WEST SUSSEX COUNTY COUNCIL CONSULTATION

TO:	Arun District Council FAO: Amber Willard
FROM:	WSCC - Highways Authority
DATE:	25 April 2022
LOCATION:	12 East Front Road Bognor Regis PO21 4SU
SUBJECT:	P/46/22/PL Demolition and erection of 1 No dwelling with detached garage, hardstanding and landscaping. This application is in CIL Zone 4 and is CIL Liable as new dwelling.
DATE OF SITE VISIT:	n/a
RECOMMENDATION:	Advice
S106 CONTRIBUTION TOTAL:	n/a

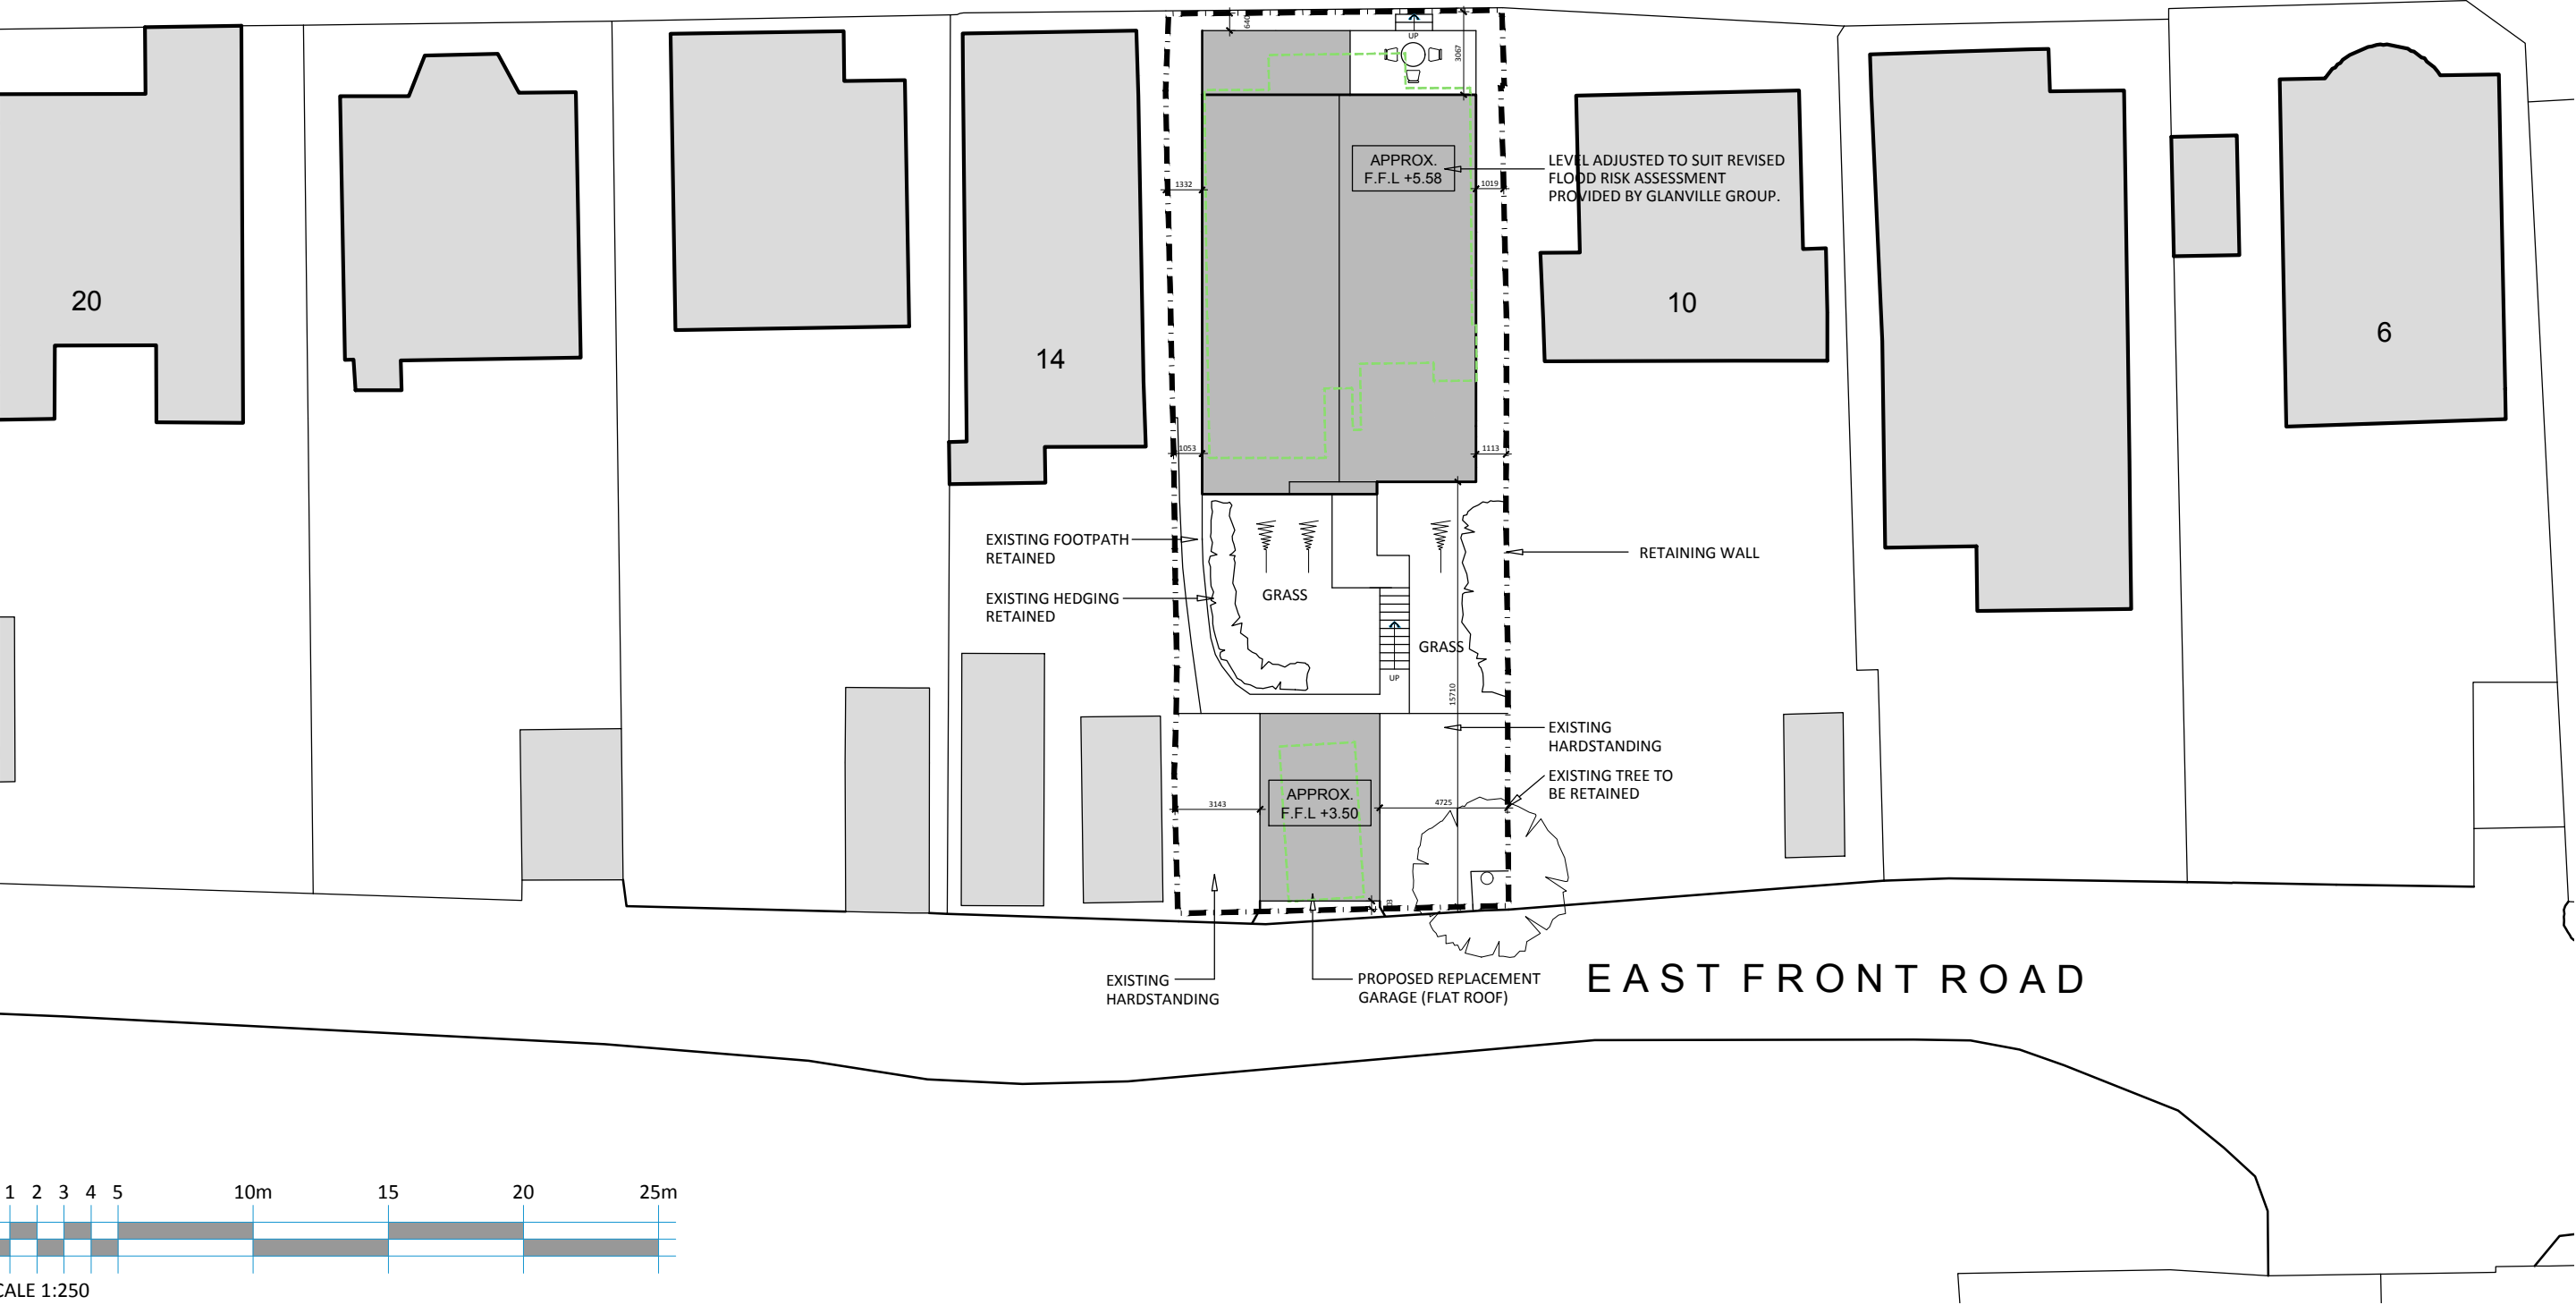
The proposed plans demonstrate parking provision for at least 2 vehicles on the retained hardstanding area and 1 vehicle parking space within the detached garage. The garage appears to exceed the minimum internal specifications of 3 x 6m as set out in Manual for Streets (Mfs). The Arun Parking Standards expects that a minimum of 2 parking spaces would be required for a dwelling of this size.

There does not appear to be sufficient space on site for vehicles to turn and exit the site in a forward gear. However, the LHA anticipate that vehicles will be able to exit onto the publicly maintained highway in a forward gear and would not raise a highway safety concern to a lack of turn on site.

The plans do not demonstrate any secure and covered cycle storage to encourage sustainable methods of transport. Details of this can be secured via condition.

No part of the development shall be first occupied until the car parking has been constructed in accordance with the approved site plan. These spaces shall thereafter be retained at all times for their designated purpose.

No part of the development shall be first occupied until covered and secure cycle parking spaces have been provided in accordance with plans and details to be submitted to and approved by the Local Planning Authority.
